Report: Road Safety Audit Stage 1**Report Title: Waterloo Square, Bognor Regis****RSA Team: Road Safety Answers Date: November 2020****RESPONSE REPORT**

Organisation: Bright Plan Ltd	Organisation: West Sussex County Council
Date: 16/11/2020	Date:

Project Title:	Date:
Waterloo Square, Bognor Regis	06.10.2020
Document Title:	Drawn by / Checked by:
Proposed Site Layout Plan	SR / GG
Drawing Scale / Sheet Size:	Client:
1:500 @ A3	B5 ltd
Drawing Status:	Drawing Number / Revision:
PLANNING	18.103.400

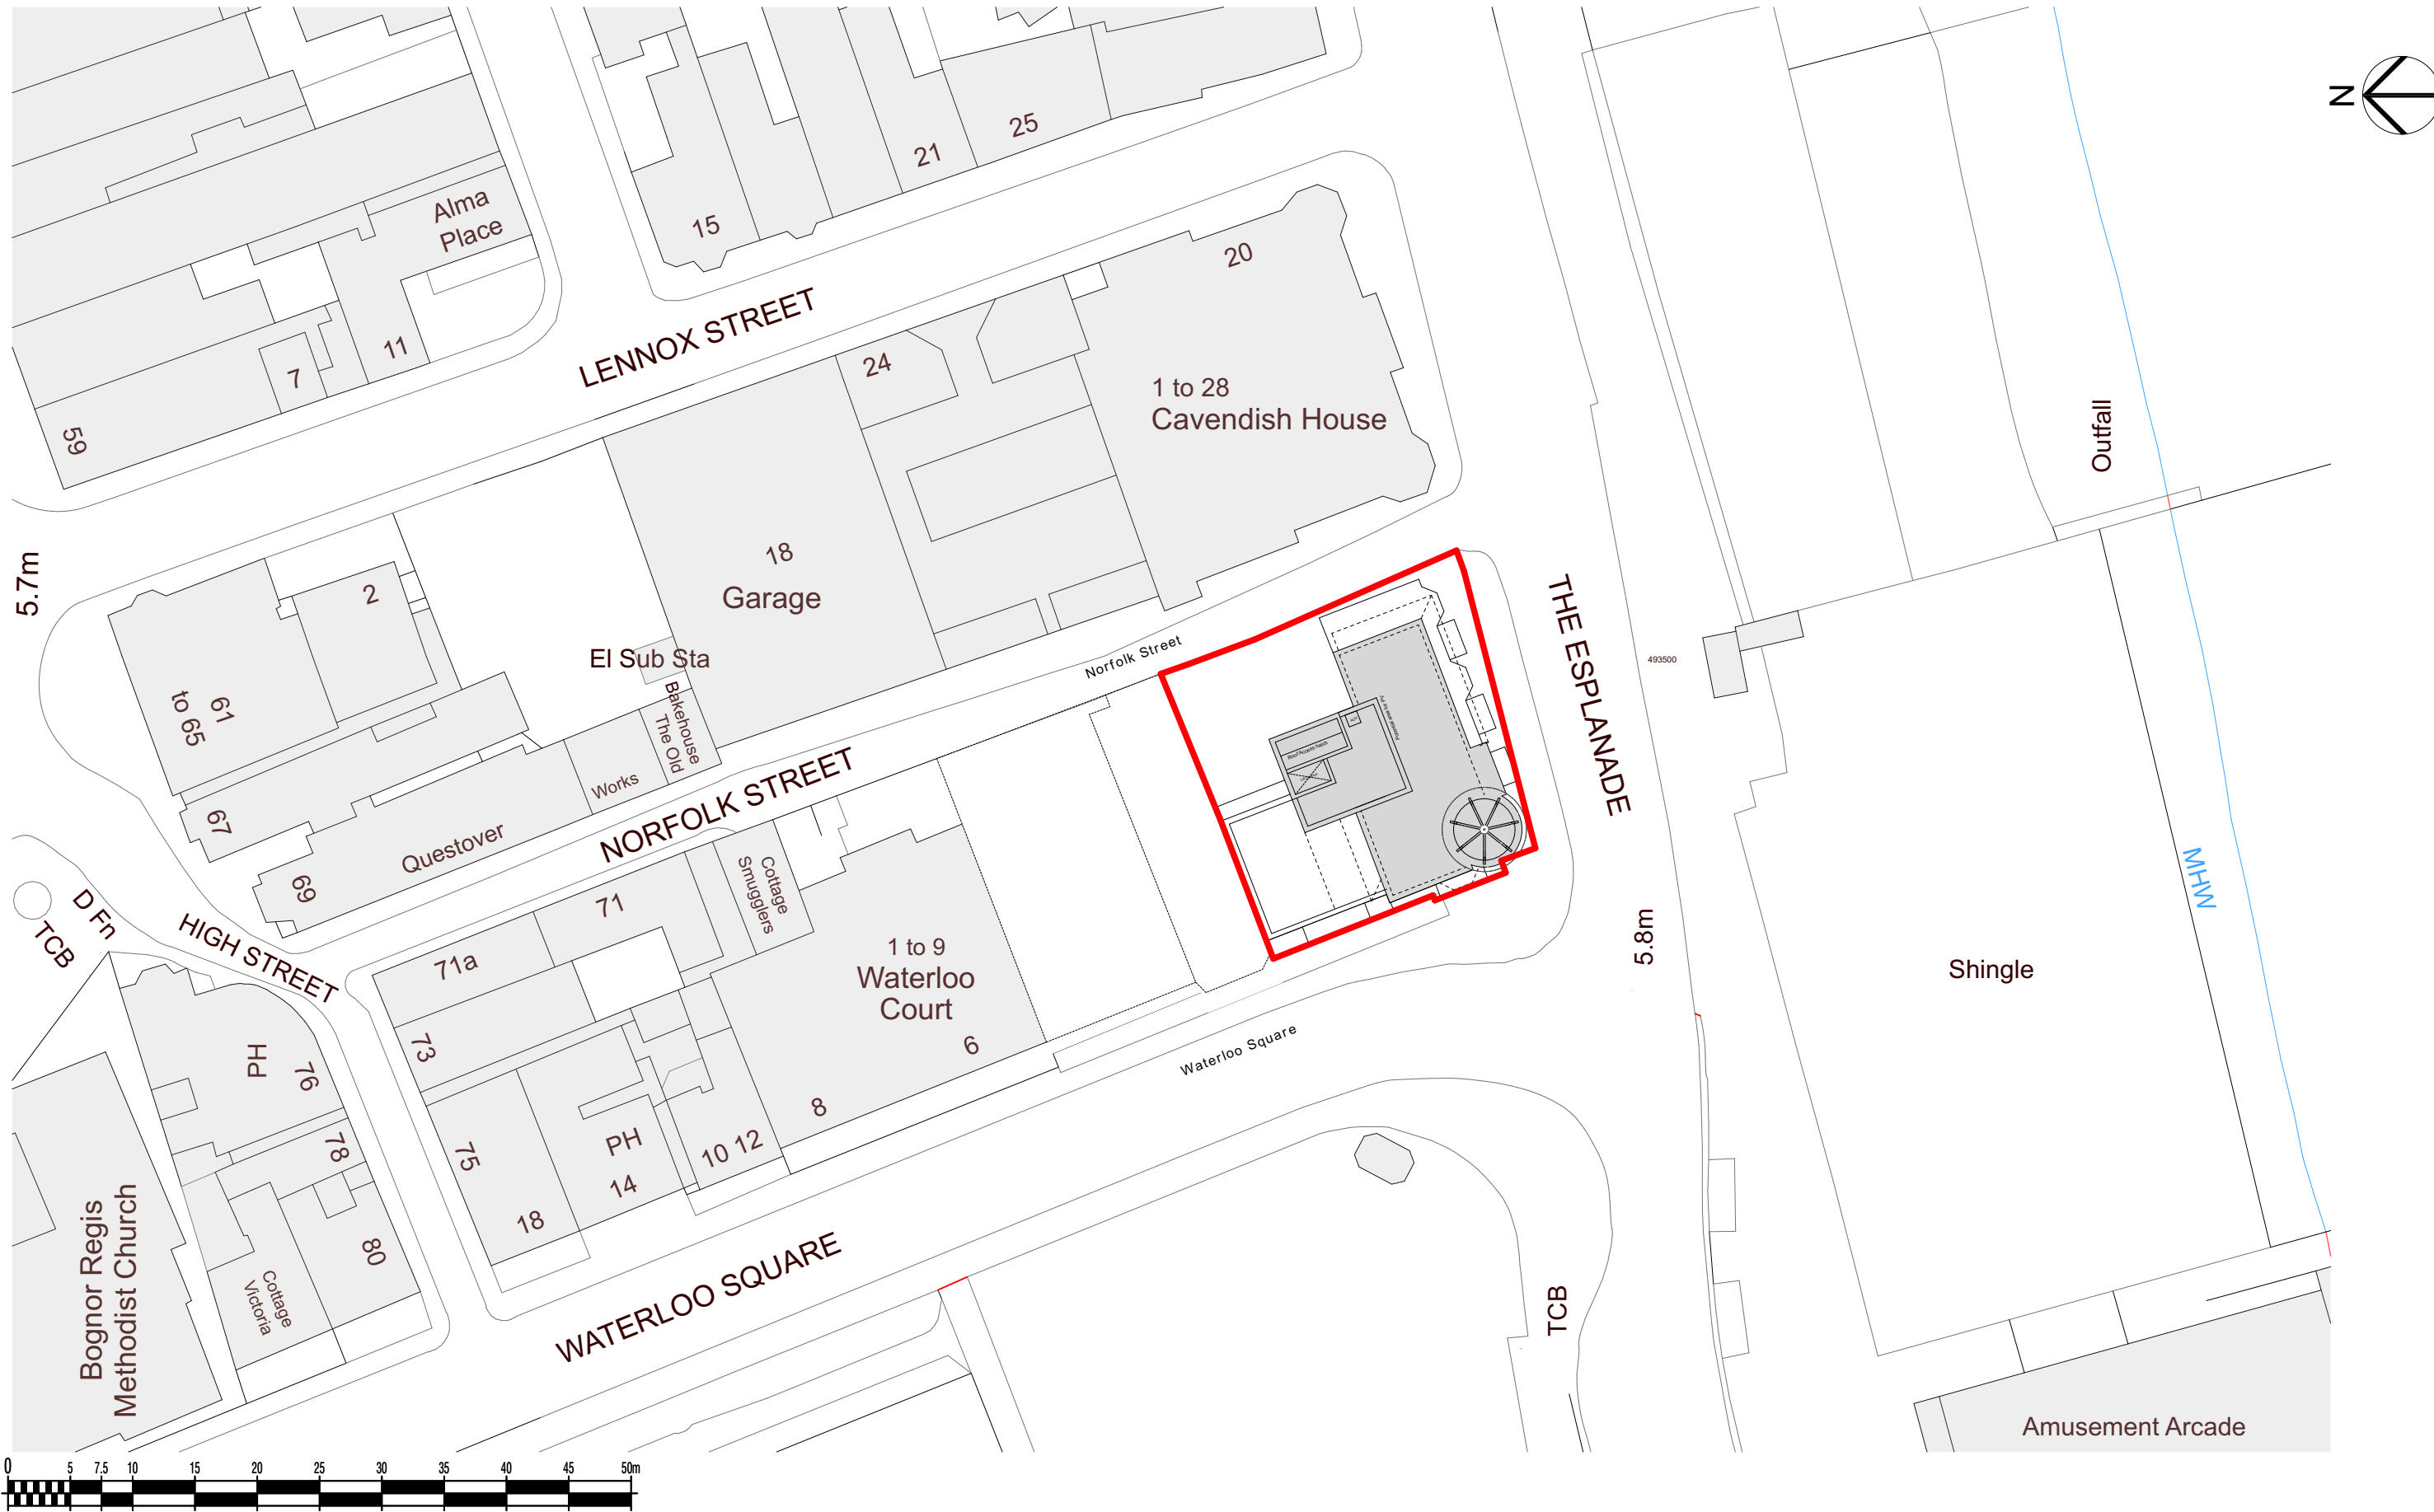
RSA Problem	RSA Recommendation	Design Organisation Response	Overseeing Organisation Response	Agreed RSA Action
The drawing does not indicate whether there will be a boundary treatment on the northern boundary on the site e.g. a wall or fence, between this development and the currently derelict site to the north. If the boundary treatment is low i.e. less than 1.05m in height, drivers exiting the proposed parking bays will be able to see over it, minimising the conflicts with vehicles approaching from the north on this one-way street. If the boundary treatment is too high, the visibility will be obscured, and the risk of a side impact increases, albeit slightly (vehicle speeds in this narrow street are low, and the parking spaces are for staff – trips to and from them will, therefore, be infrequent).	Any boundary treatment along the northern edge of the development should be kept below 1.05m.	Agreed The designer has proposed no boundary treatment in this location.
